**Application reference: EN010115**

### **Five Estuaries Offshore Wind Farm Project**

## Appendix 1: Response to section 51 advice / section 55 observations

**DRAWING NUMBER:** 005023883-01  
 APFP Regulation: 5(2)(m)  
 Sheet No: 3 of 20  
 SCALE: 1:2,500 PLOT SIZE: A1 DATUM: OSGB 1936 PROJECTION: BNG

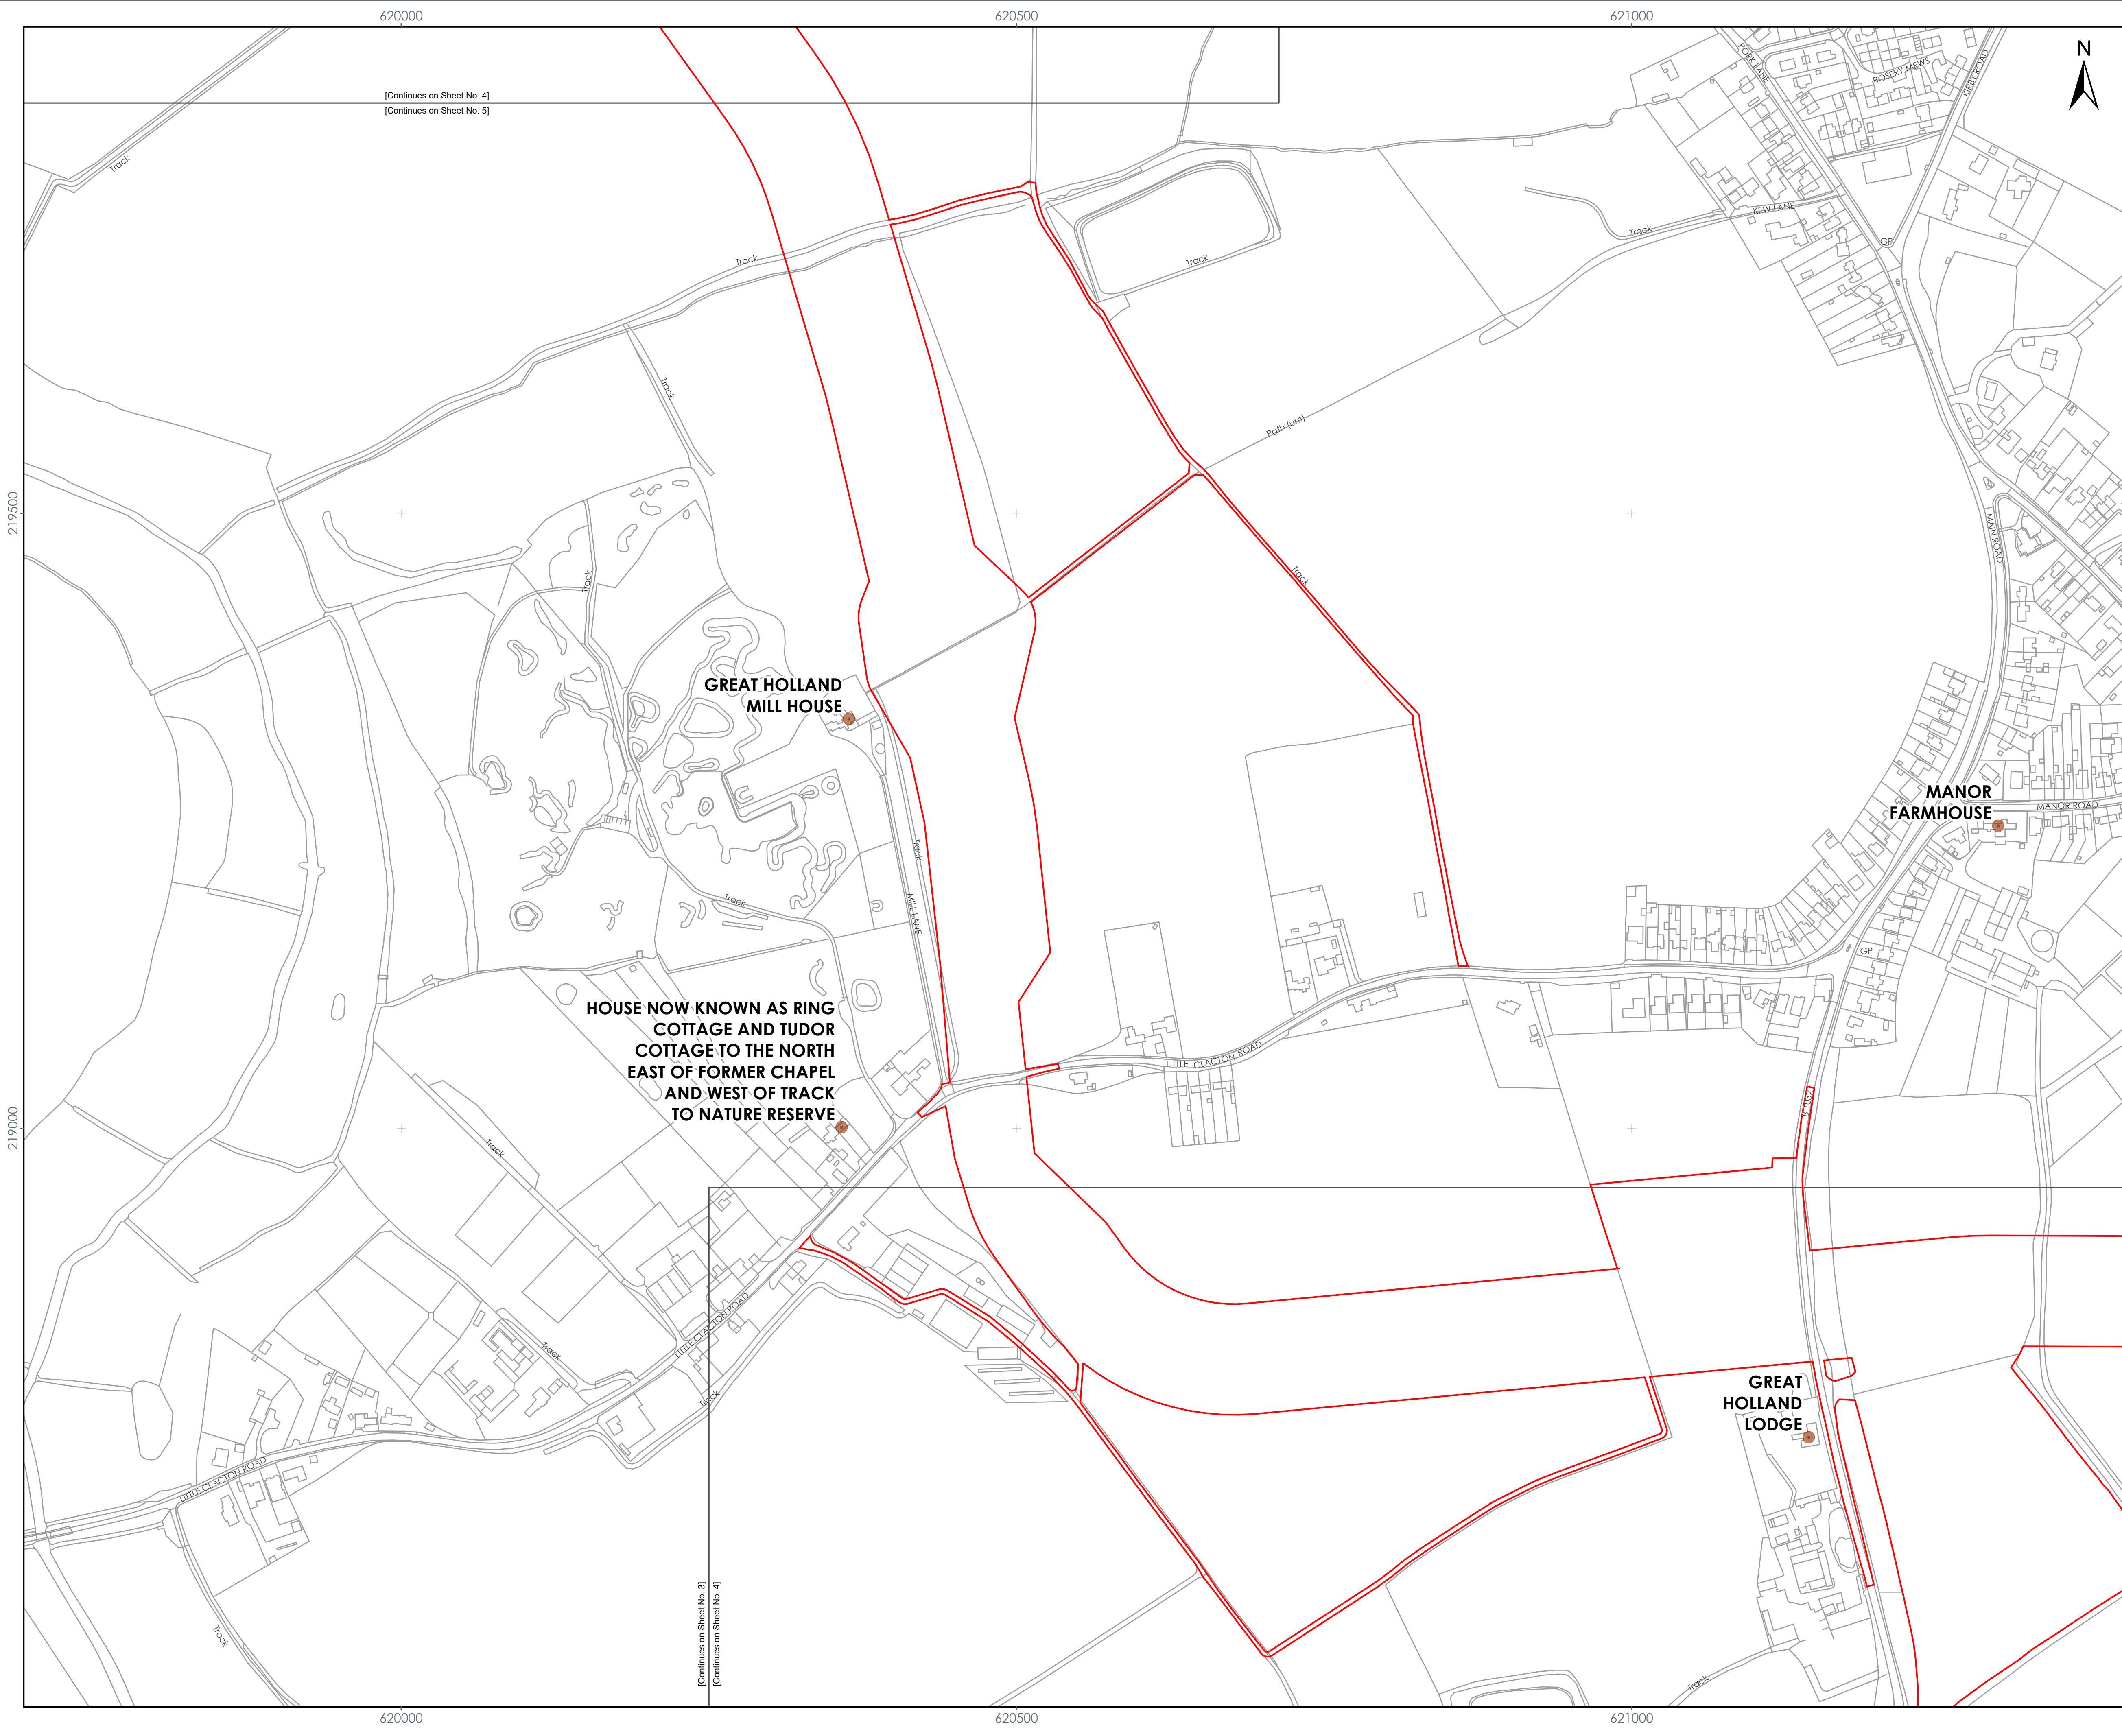
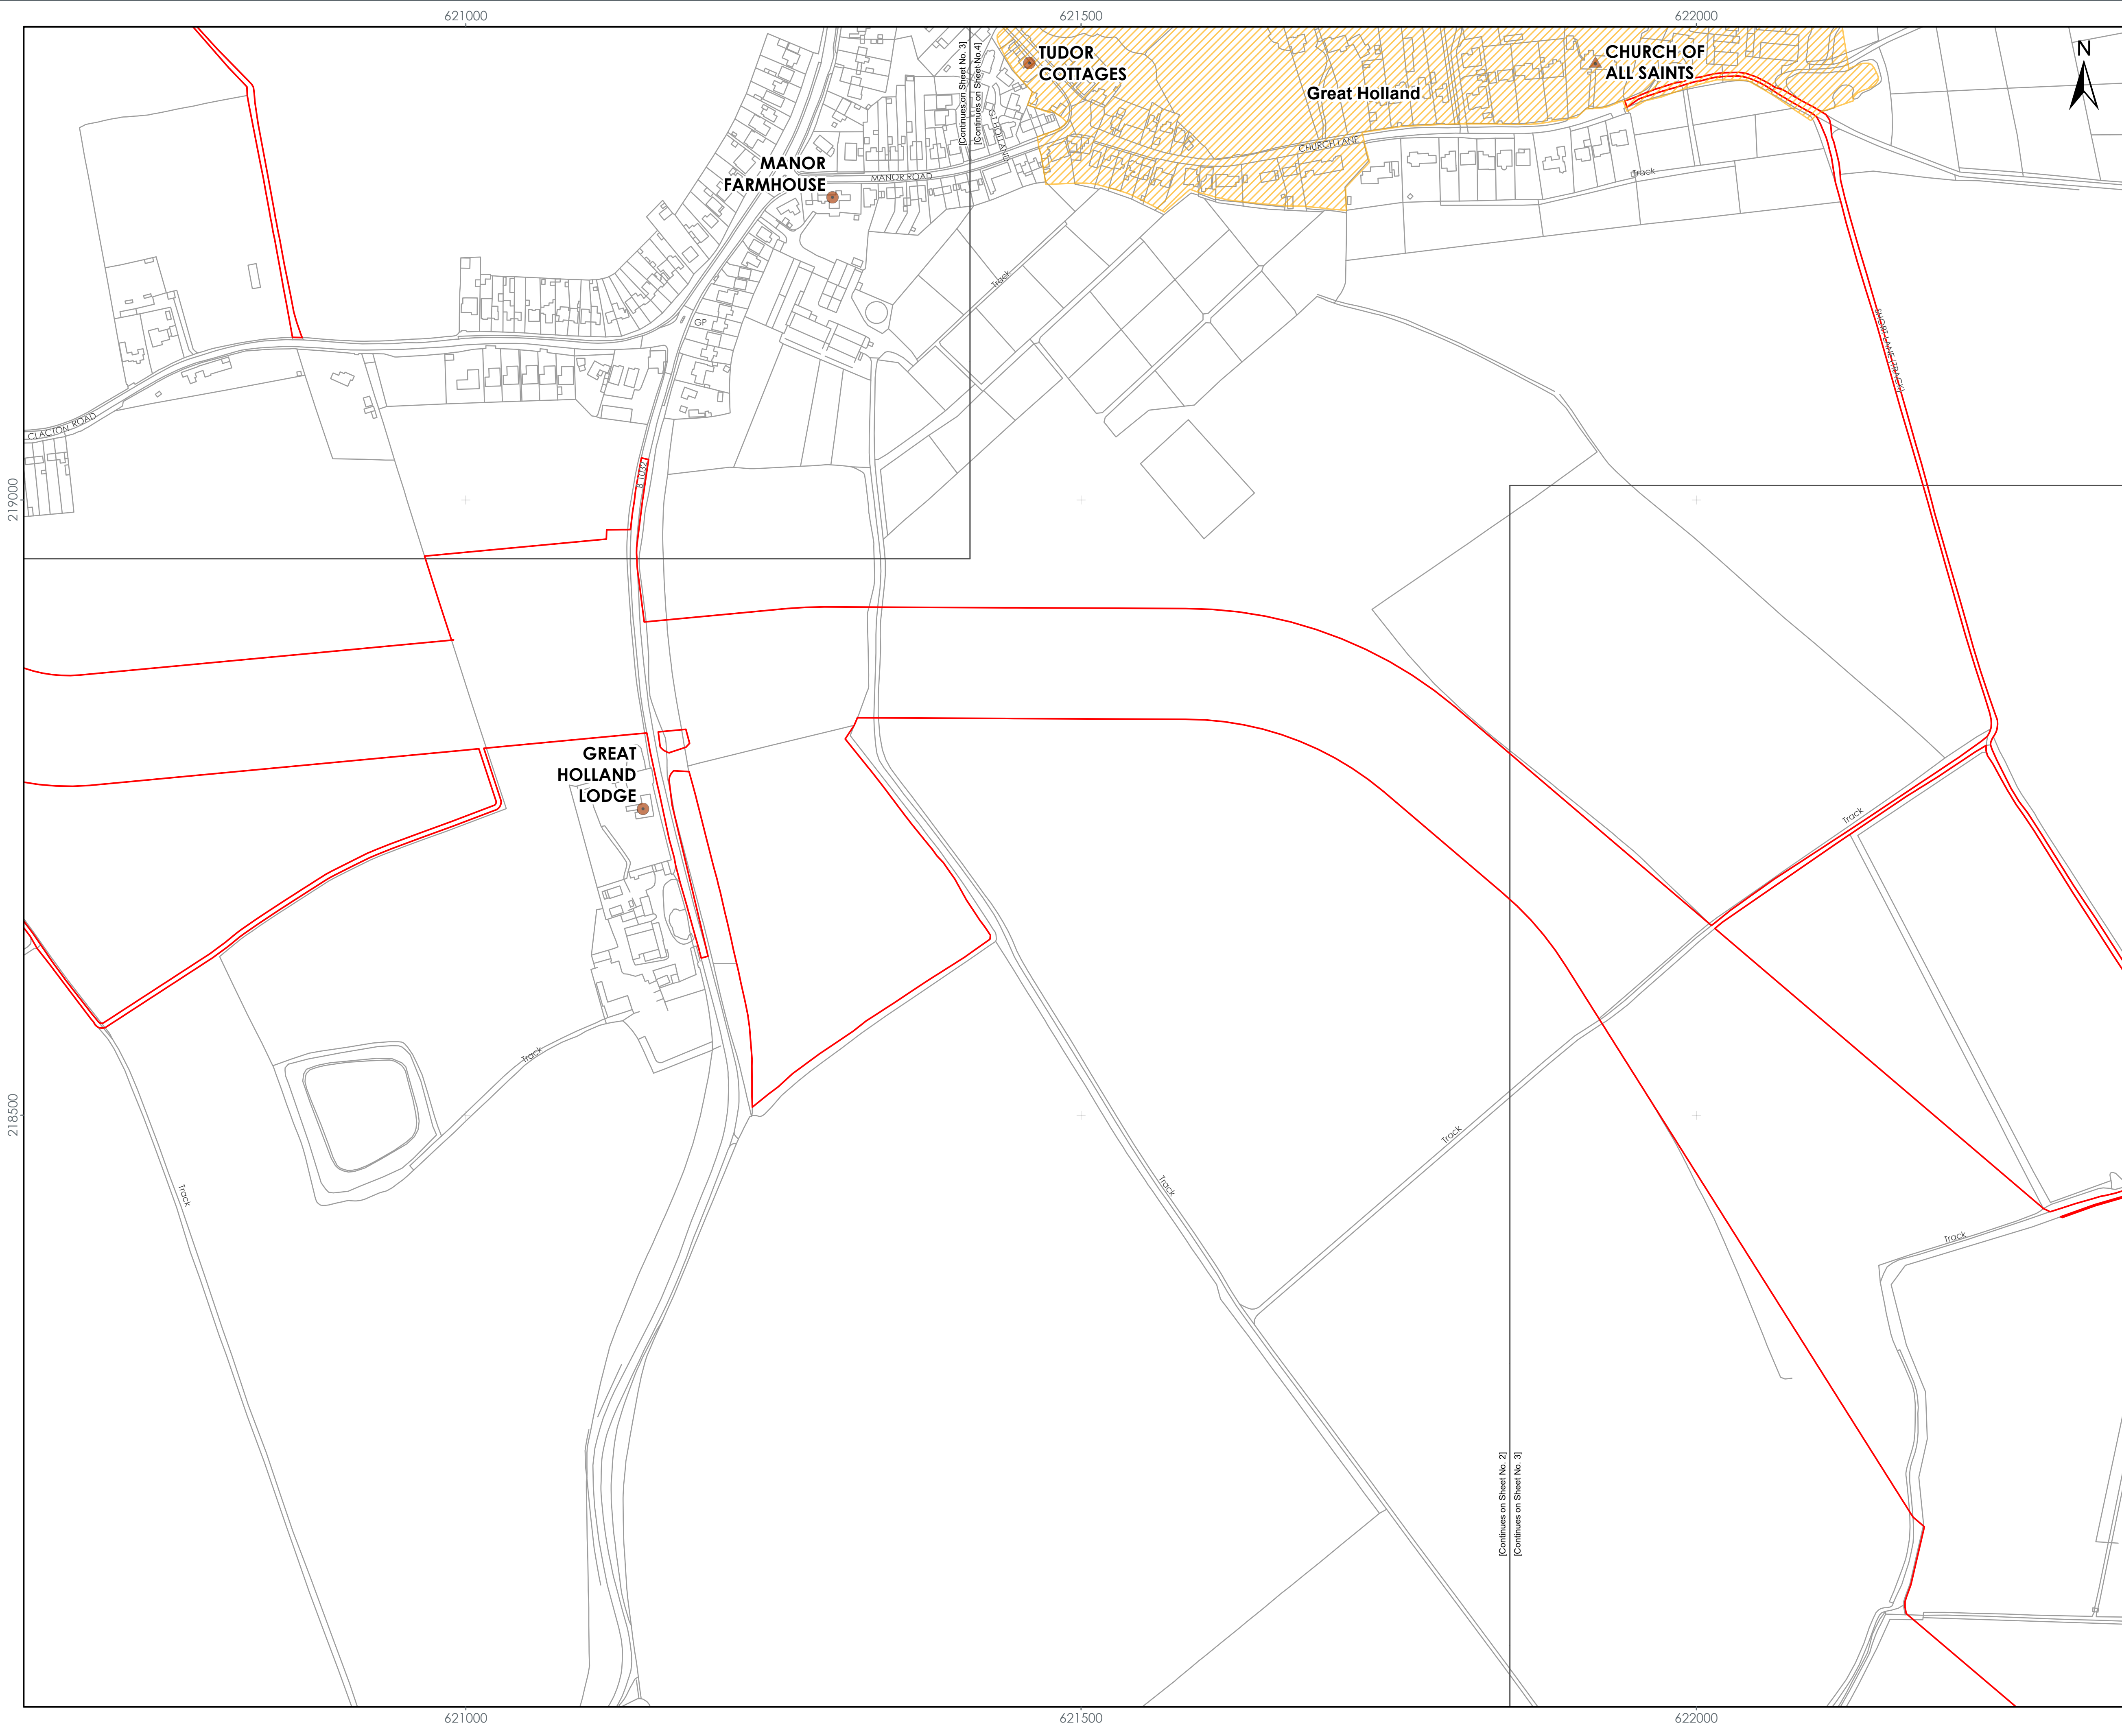
Sheets 1 to 7's are difficult to read due to the resolution being low.	all consistent, rather than having different base mapping.
Historic Environment Plan – Onshore (document reference 2.11)	Historic environment plans show a woodland layer on the key, but this is not visible on the plans. These plans also show ancient woodland which may not be required in the historic environment context and could be included in the Statutory or Non-Statutory Sites and Features of Nature Conservation - Onshore plans (Doc 2.13).	No changes are proposed at this stage as the woodland layer is not key to understanding the plans or a statutory feature.  The project notes that ancient woodland is already included on Statutory or Non-Statutory Sites and Features of Nature Conservation - Onshore plans (document reference 2.13).
Crown Land Plan – Onshore (document reference 2.17)	The colour used for Crown Land in the Legend of Sheet 2 of 2 does not seem to match the colour used on the plan.	No changes are proposed. The land parcel 20-002 shown on Sheet 2 of 2 of the Crown Land Plan – Onshore (document reference 2.17) has land interests from both parties in the key. It is therefore correct as shown.

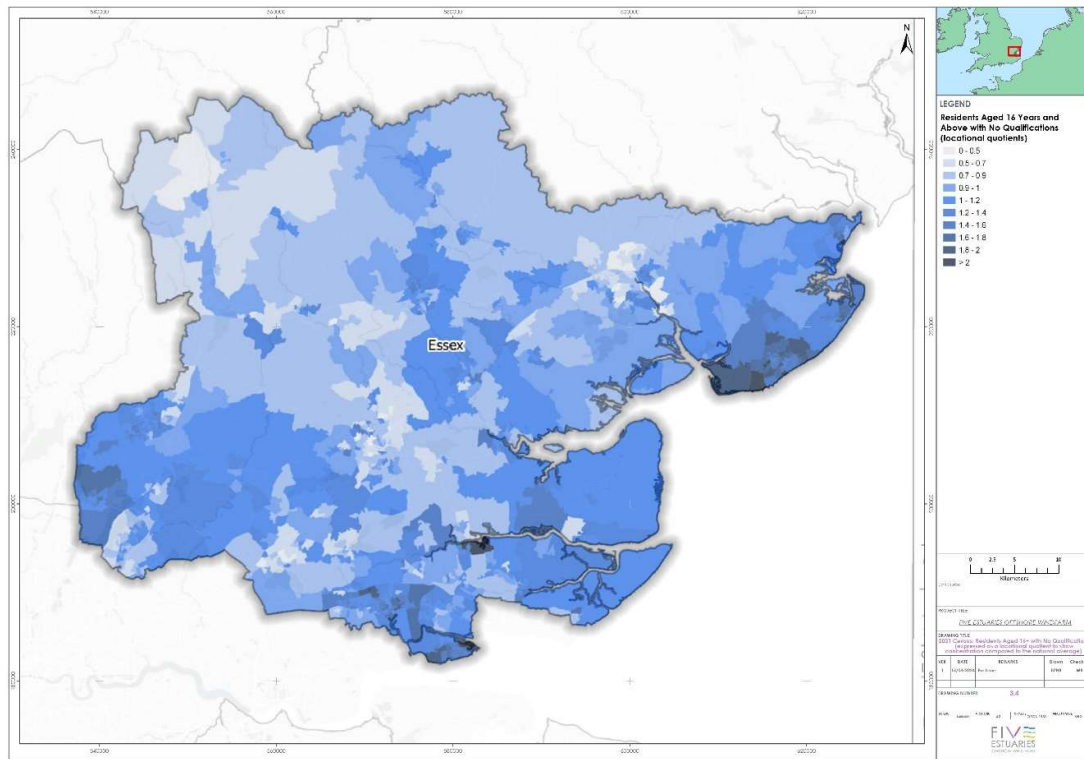
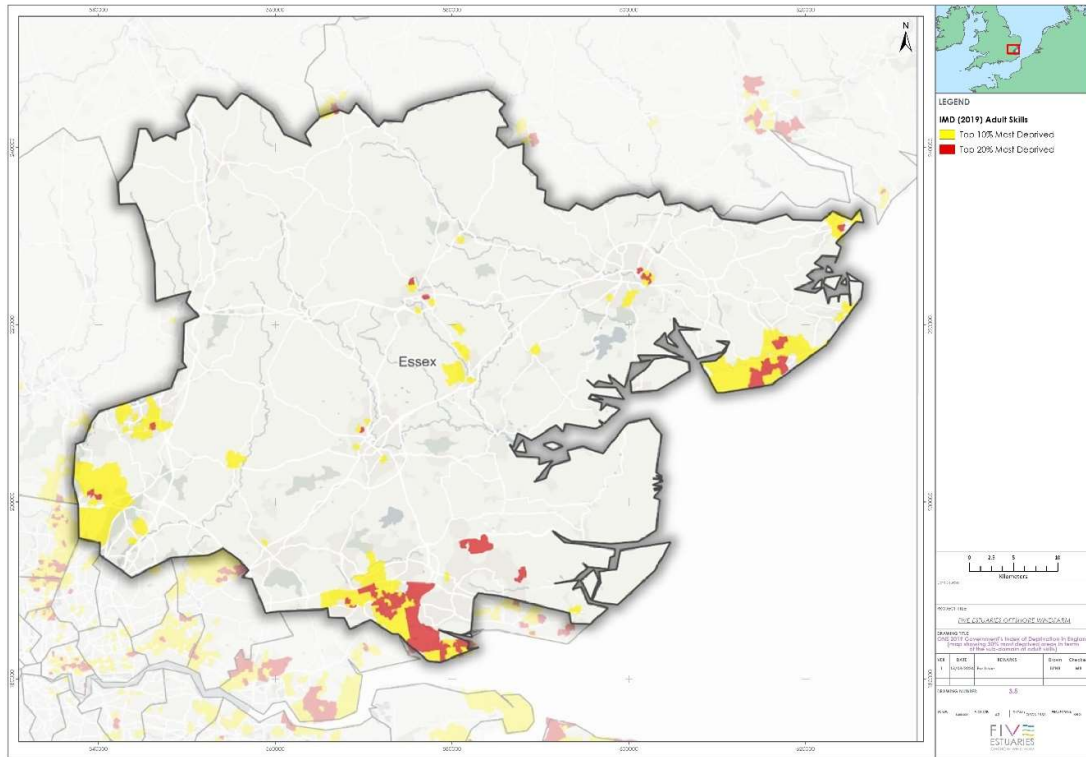
<p>Outline Skills and Employment Strategy (document reference 9.27)</p>	<p>The ledgers for figures 4 and 5 are not legible due to the resolution being too low.</p>	<p>No changes are proposed at this stage. This will be updated and submitted for a future deadline.</p>
